A BETTER MAINE LLC

8 July 2013

Re: 227 York Street, Project ID# 2013-00996 / City review letter dated June 26, 2013

Drawing Number
S200

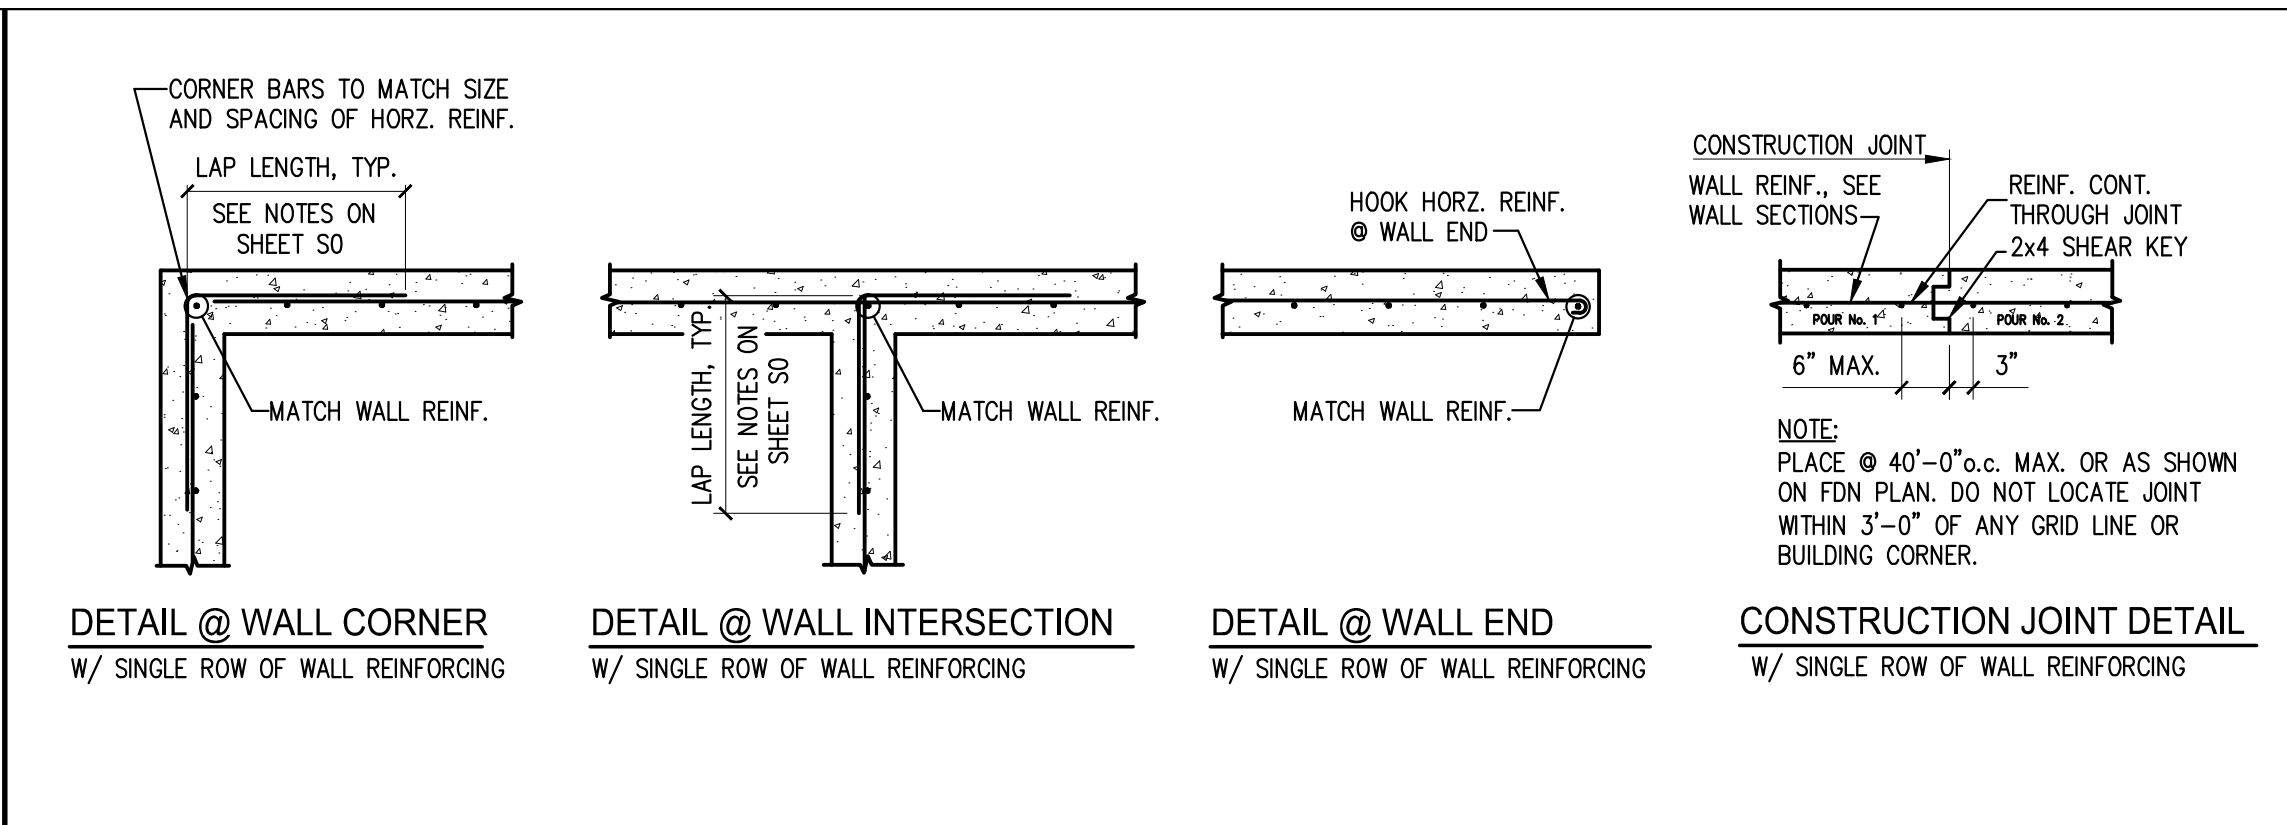
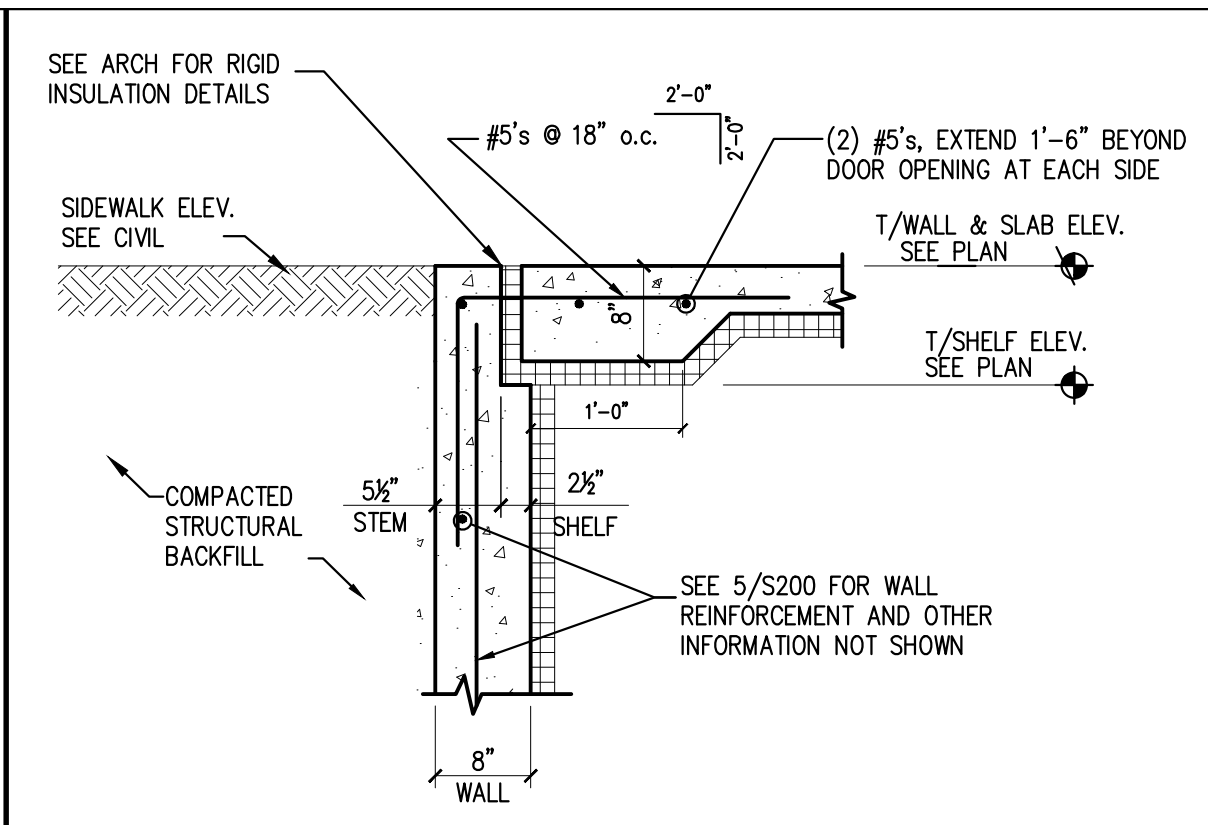
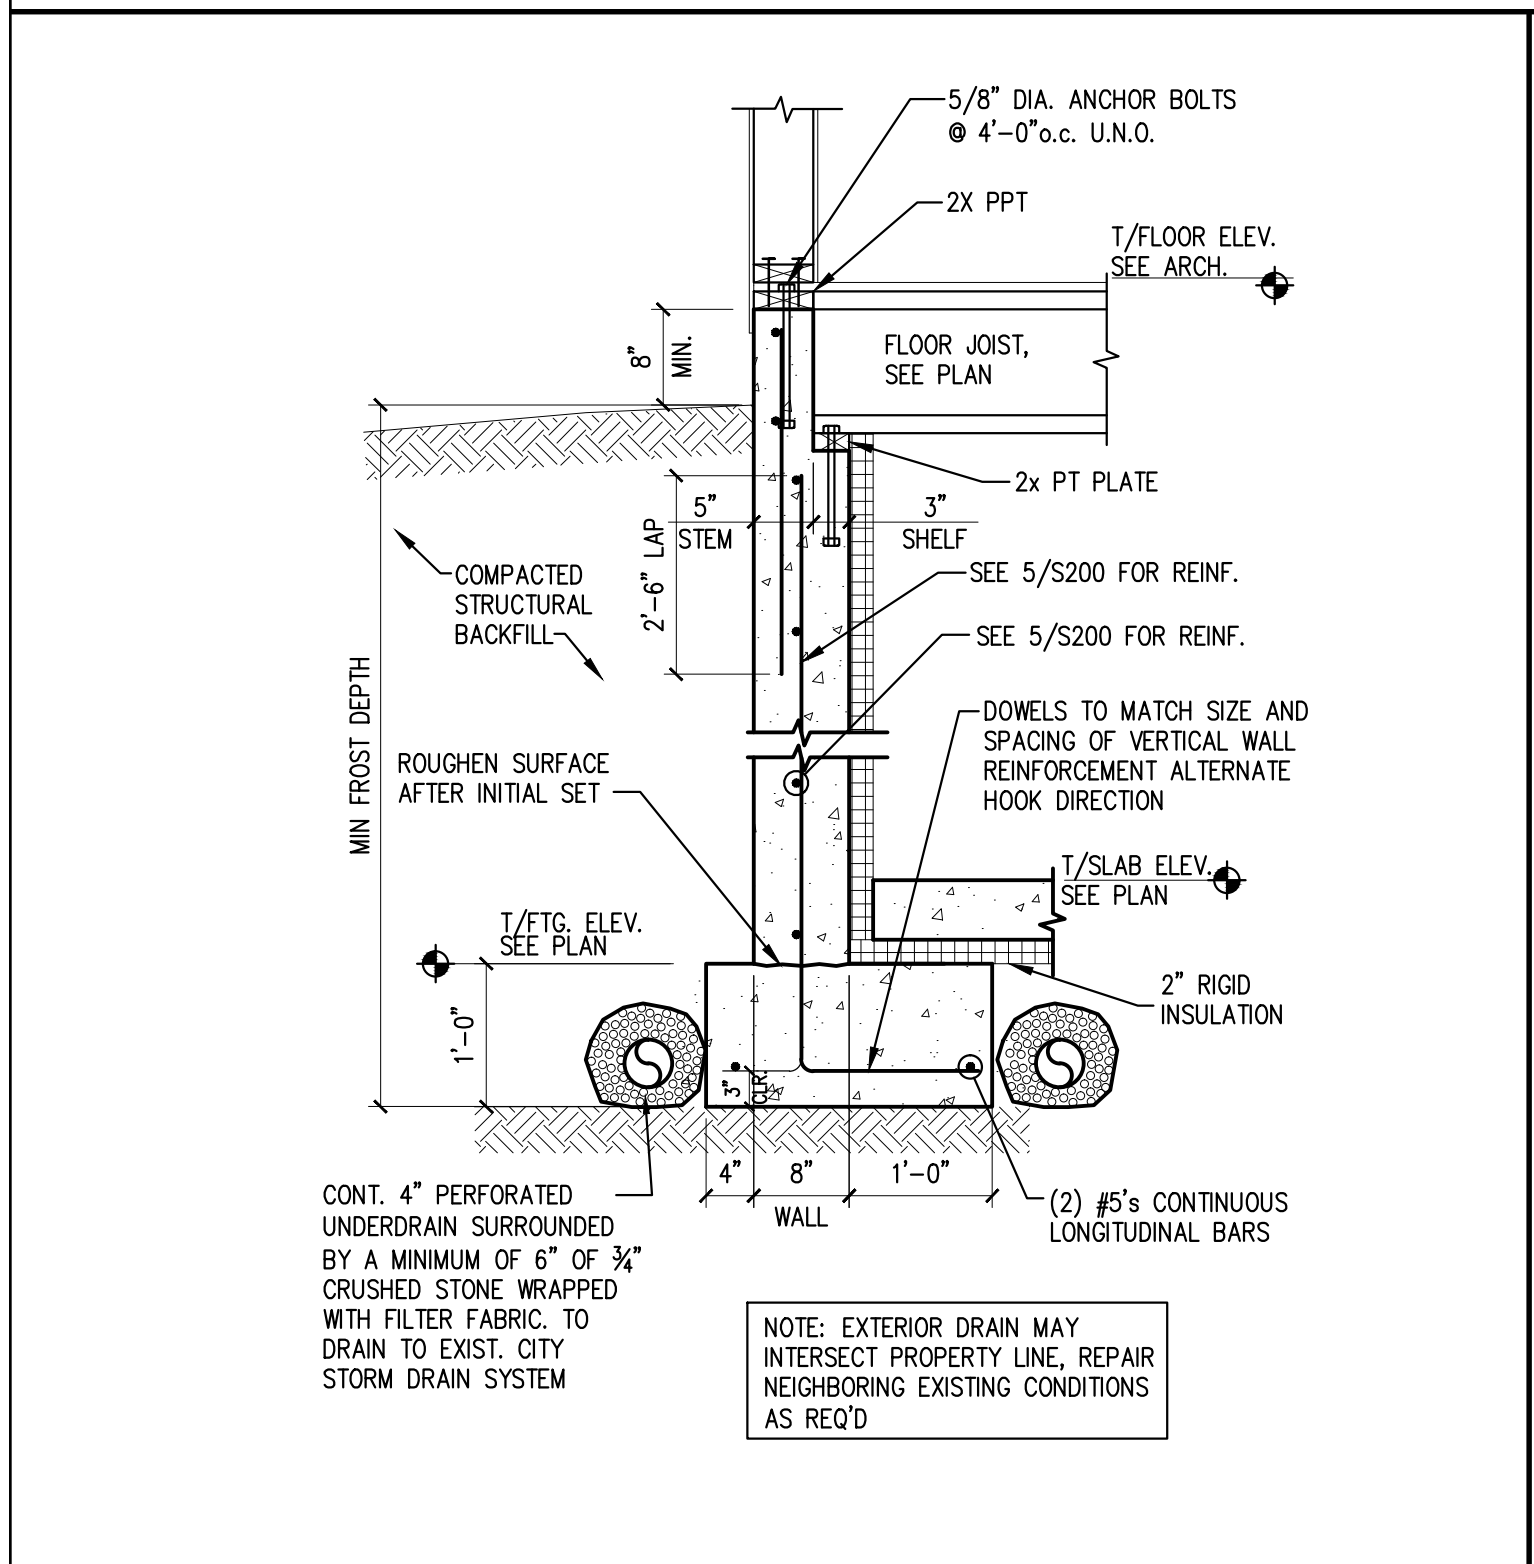
11. Site Plan/**Site Disturbance area**: Please see the revised Site Plan, Drawing C101 dated (revised) 7/5/13, now noting the area of disturbance.
12. Site Plan/**Foundation Drain**: As shown on Drawing S200, the foundation drain is intended to be connected to the City Storm system as there is no other feasible way to direct this drain. It is re-noted on attached Site Plan C101.
